Terrestrial Biodiversity

Figure 12 – Local GI assets

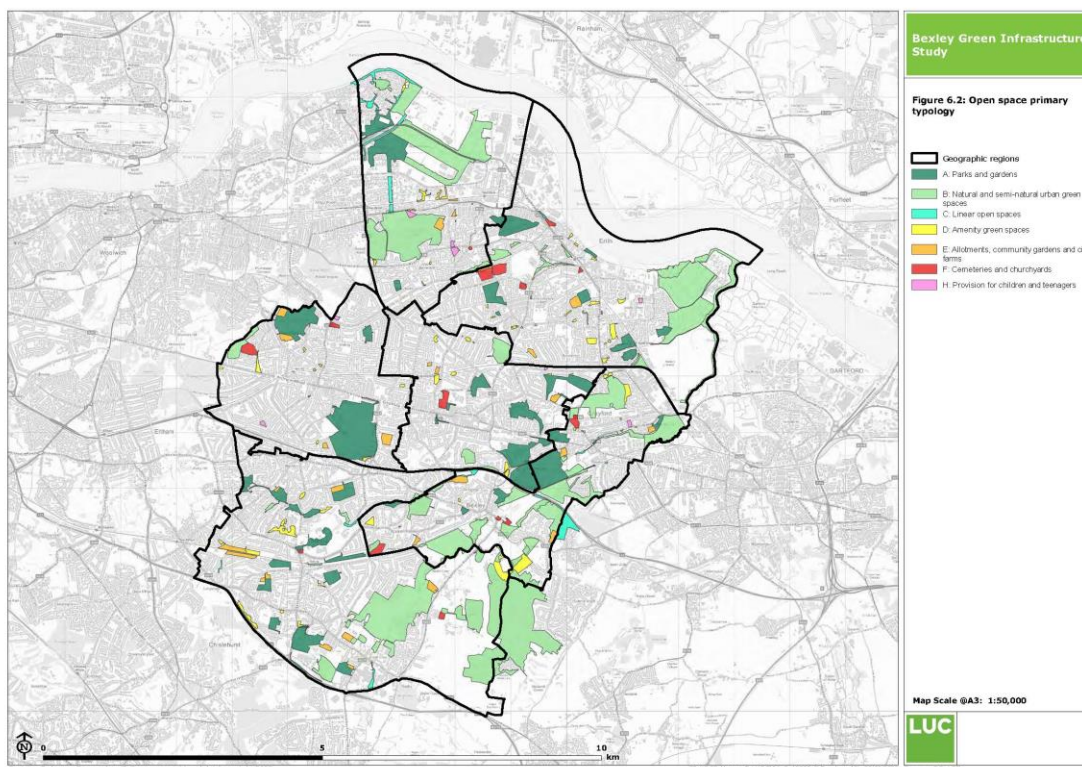
<p>to indicate that Lagoon Field and Island Field were not surveyed¹², even though the Applicant appears to be identifying Lagoon Field as a potential receptor site for the relocated stable block, Public Footpath 2 (Fig 9 of the LaBARDS), and the relocated STW emergency access/egress road, (as presented verbally during a site visit with TWUL's tenant graziers and Crossness Nature Reserve Manager on 14th May 2024). Similarly, Island Field and Island Field Lagoons did not form part of the Wintering Bird Survey¹³ (as demonstrated by the lack of survey results shown in Fig 7-27 – Overall Distribution of Waterbirds – Figures – Part 1) despite those parcels of land being identified as part of the Project's 'Mitigation and Enhancement Area'.</p>	<p>Field, no interventions (through the Proposed Scheme directly or habitat creation and enhancement) are proposed in these areas – they are instead proposed to be managed as part of the overall expanded Crossness LNR. Ecological surveys focused on the development footprint and areas within the Mitigation and Enhancement Area (i.e. Norman Road Field) where measures proposed in the Outline LaBARDS (REP1-012) would be focussed, with the application of an appropriate survey buffer. However, the evaluation of the Site for protected and/or notable species (including bats, wintering and breeding birds) took into account not just field survey results, but also desk study information including records noted by Thames Water at Crossness LNR from 2015 to 2022, as well as those held by Greenspace Information for Greater London (GiGL). These sources provided an appropriate and robust baseline for the evaluation of the Site's importance for protected and/or notable species to inform the assessment in Chapter 7: Terrestrial Biodiversity of the Environmental Statement (Volume 1) (APP-056).</p>	<p>stables, the rerouted public footpath, and potentially the rerouted TWUL access road, so there are potentially direct interventions and further habitat loss which have not been assessed.</p>
